DRAFT STATEMENT OF COMMON GROUND WITH PEEL NRE LIMITED

HyNet Carbon Dioxide Pipeline DCO

Document Reference Number D.7.2.8

REVISION: E

DRAWING TITLE
 Figure 19.1 Other Developments Sheet 1 of 3

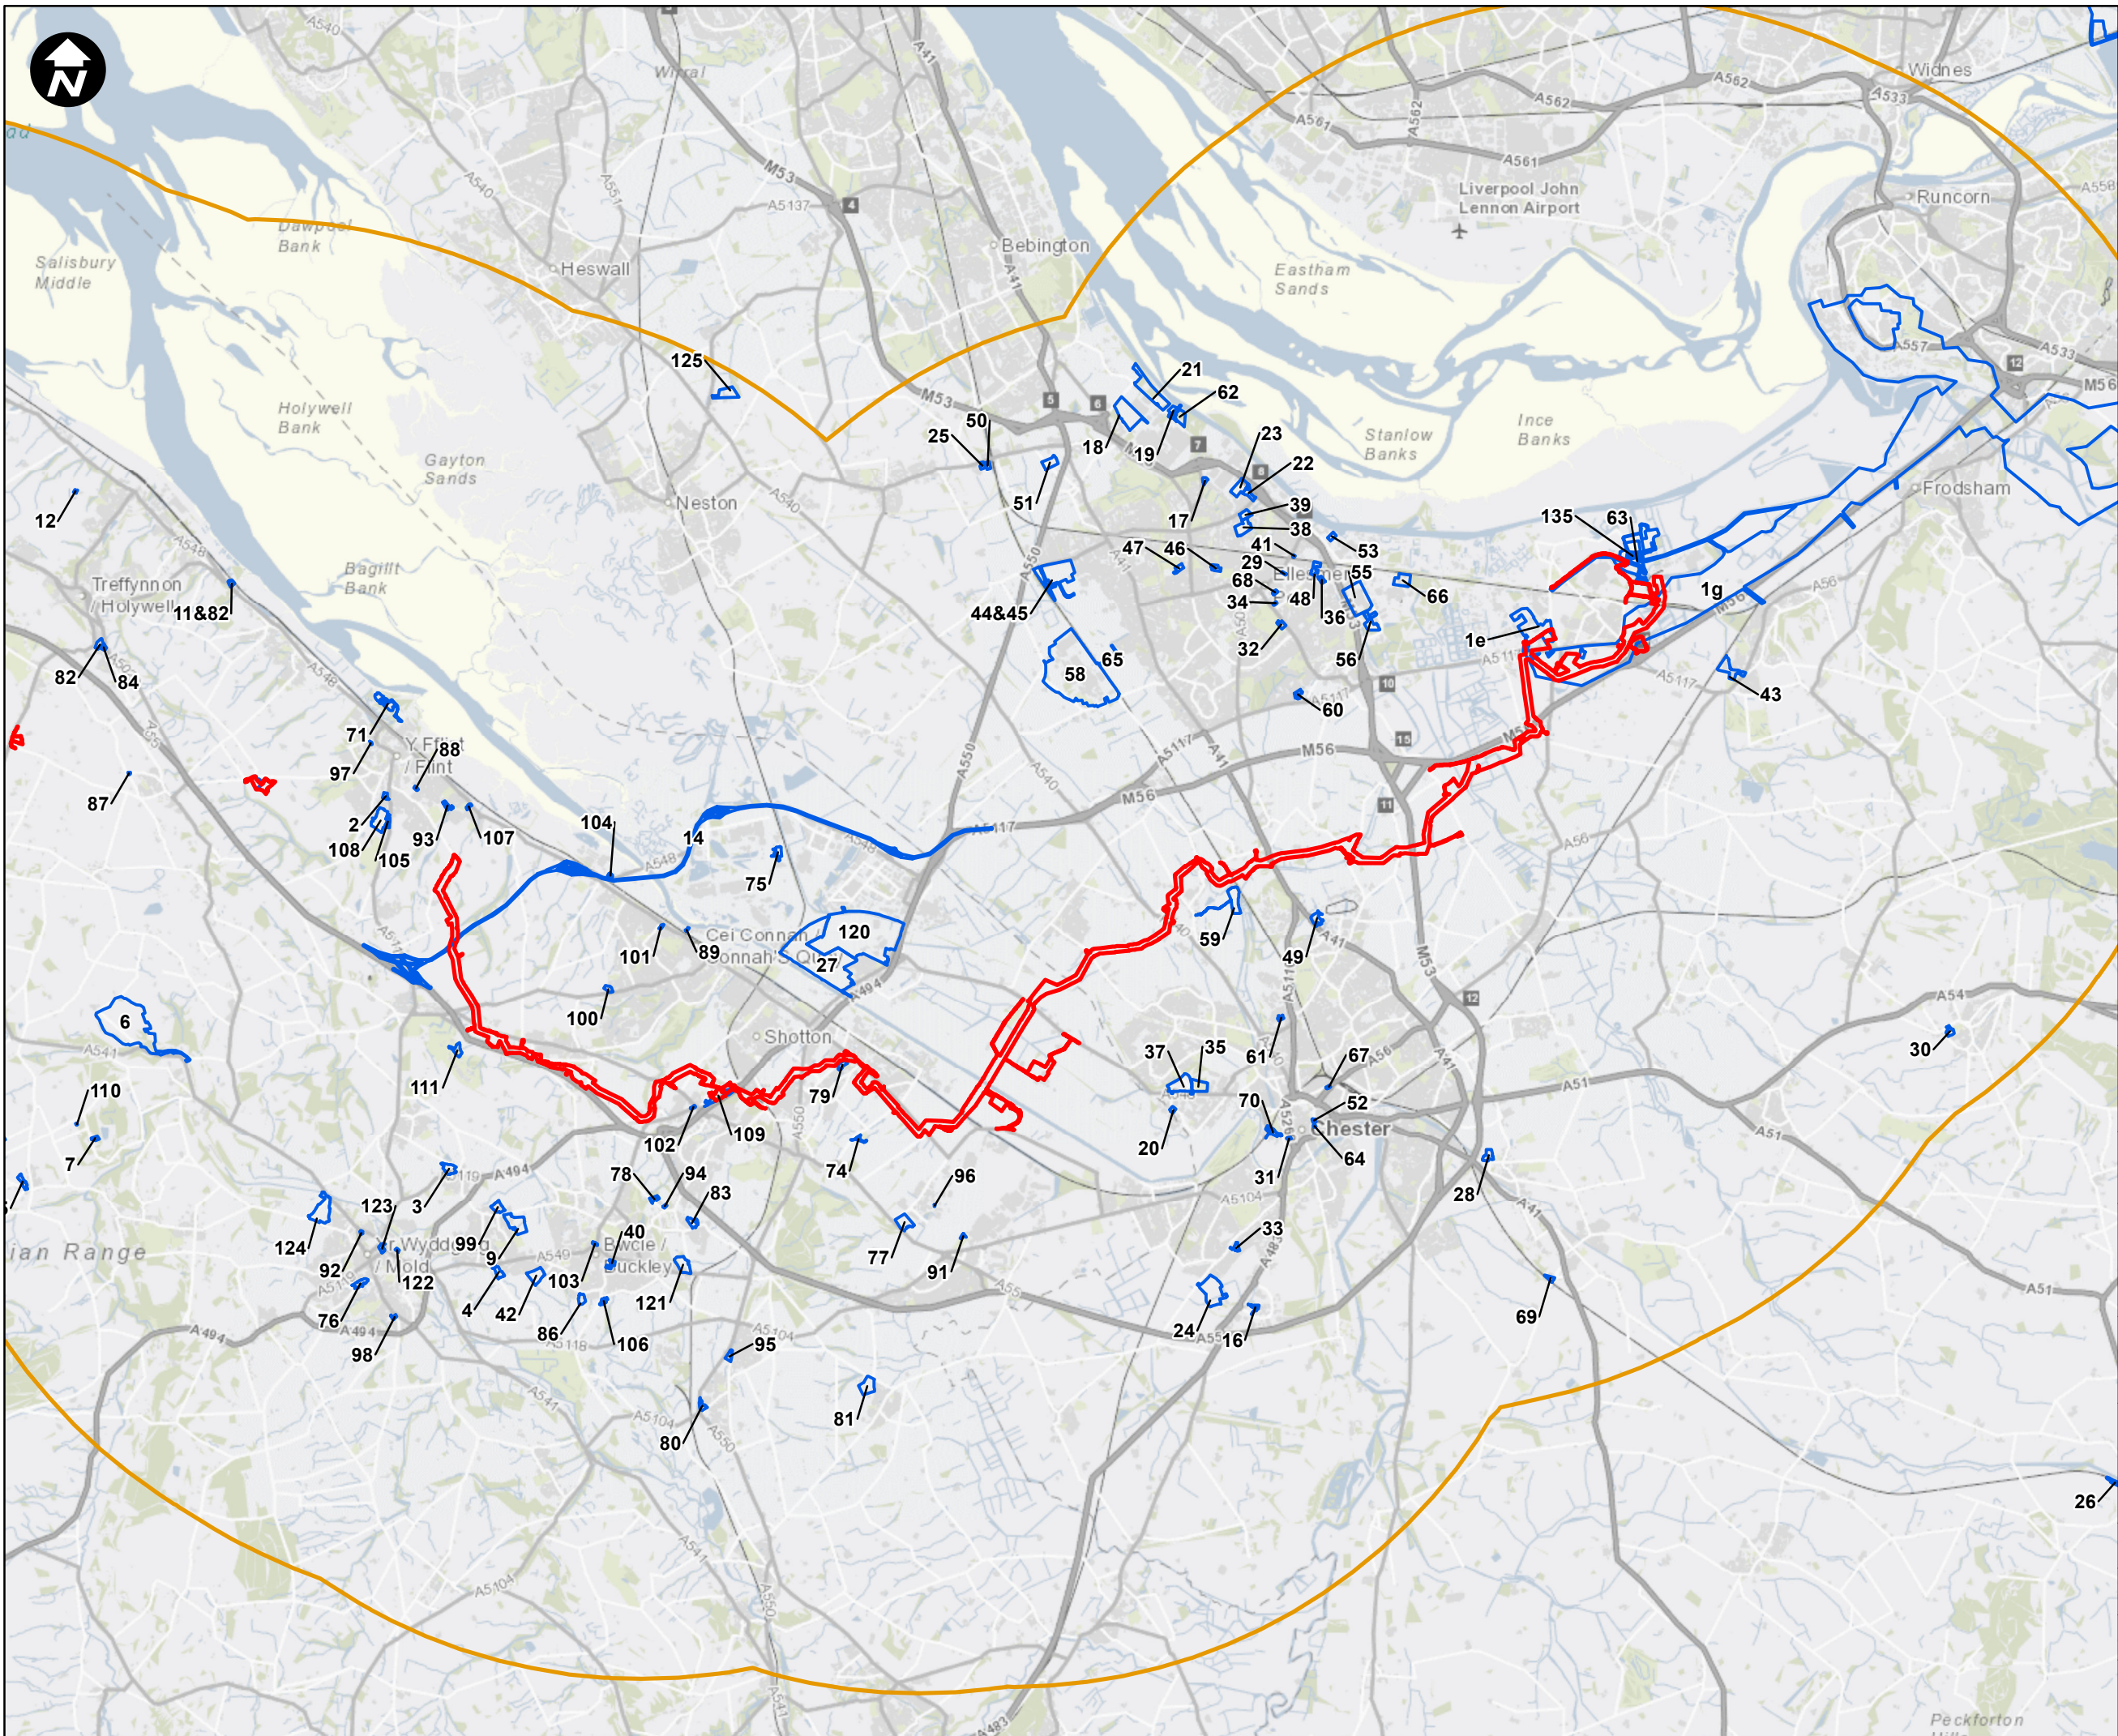
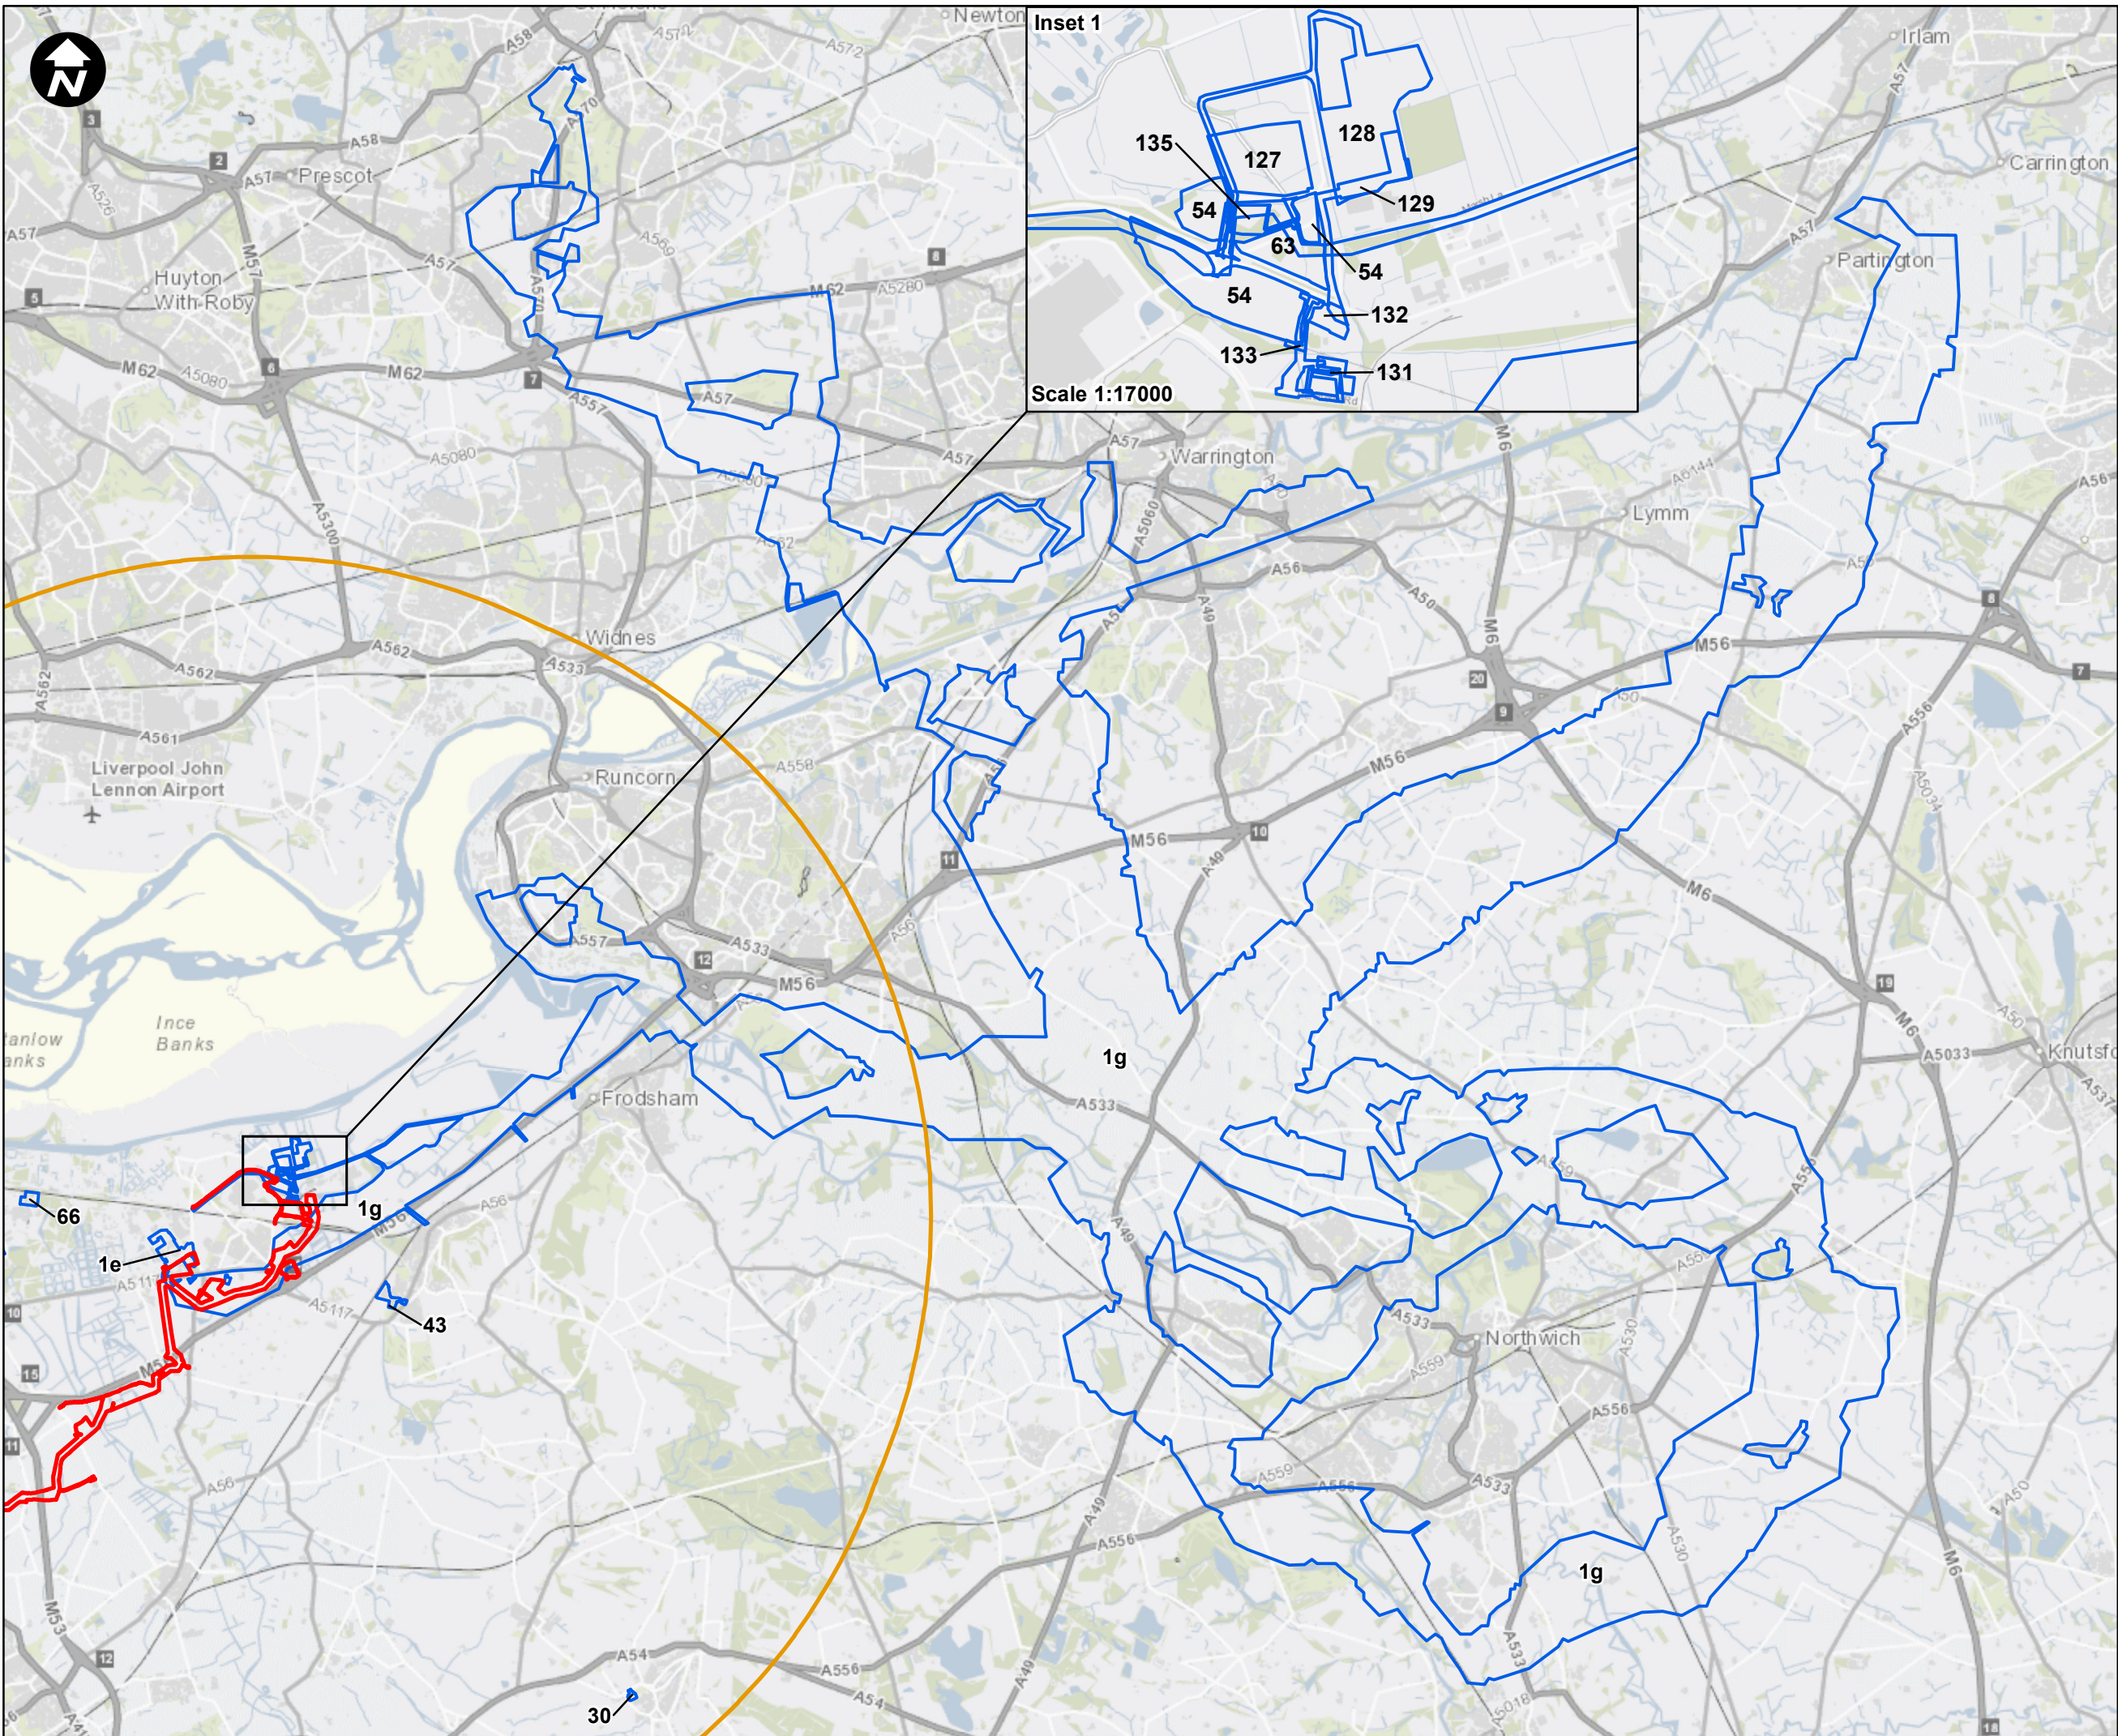
Peel 3.1.3.1	ES – Inter Project Effects	<p>Peel has reviewed the information provided and intends to make the following comments.</p> <p>Within Appendix 19.1 (Table 2) [CR1-044] and on Figure 19.1 [CR1-099], three projects have been identified within the Ince Resource Recovery Park (Protos) strategic employment allocation¹ comprising:</p> <ul style="list-style-type: none"> • ID 1e(iii) - TCPA – CWACC: 19/03489/FUL Development of a hydrogen production plant (HPP) and electricity generating plant, comprising of a waste reception and handling building, gasification facility, hydrogen production facility with associated/ ancillary infrastructure which includes access roads, weighbridge, fencing / gates, lighting, surface water drainage, and electricity distribution plant; • ID 54 TCPA - CWACC Reference: 21/04076/FUL: Materials recycling facility, two plastics recycling facilities, a polymer laminate recycling facility and a hydrogen refuelling station (Protos Plastics Village); and • ID 63 TCPA - CWACC Reference: 20/04396/FUL: Resource recovery facility (Plastics Recycling Facility). <p>In addition to the above ‘Other Developments’, there are a number of other extant permissions which have not yet been implemented or are under construction as of Spring 2023 which lie within the land owned by the IP at the strategic safeguarded site “Protos”.</p> <p>These include the following:</p> <ul style="list-style-type: none"> • Plot 1 – Dry Cargo Facility (approved under application ref: 14/02277/S73) – not built. Construction start date tbc. • Plot 2 – Soil Treatment Facility (approved under application ref: 14/02277/S73) – not built. Construction start date tbc. • Plot 3 – Timber Recycling Plant (TRP) (approved under application ref. 14/02271/S73, date 26 March 2015) – the Timber plant is built and operational. • Plot 4 – Bio-Substitute Natural Gas Renewable Fuels Facility (BioSNG) (approved under application ref. 18/04671/WAS, date 16 March 2022) – construction is anticipated to take 27 months. Construction start date tbc. • Plot 5 – Integrated Waste Management Facility (IWMF) – including a In Vessel Composting (IVC) Plant, a Materials Recycling Facility (MRF), and a Mechanical Biological Treatment (MBT) Facility (approved under application ref: 14/02277/S73) – not built. Construction start date tbc. • Plot 6 – Plastics Recycling Facility (approved under application ref: 14/02277/S73) – not built. Construction start date tbc. 	Under Discussion

Due to the proximity of these developments and potential for inter-project effects due to the presence of common sensitive environmental receptors (specifically in respect to air quality, traffic and transport and biodiversity) due consideration of the Other Developments listed above should be provided as part of the assessment of cumulative effects.

A review of the list of applications provided by Peel has identified developments that would meet the criteria for inclusion in the long-list of the Inter-Project Effects Assessment (Table 2 of Appendix 19.1 of the 2022 ES **[CR1-044]**). These developments, (references: 14/02277/S73 (including Plots 1-3 and 5-7), 18/04671/WAS (Plot 4), 19/02566/FUL, 17/02683/FUL (Plot 15) and 18/01543/S73 (Plot 8)) have now been assessed and will be included in the updated ES towards the end of the DCO examination. The result of this assessment is summarised below.

The Applicant intends to update the ES cumulative chapter with these points captured, at which point it would be ready for Peel review. This will be issued on w/c 21st August 2023 latest. If the document is available earlier, this will be sent as soon as possible.
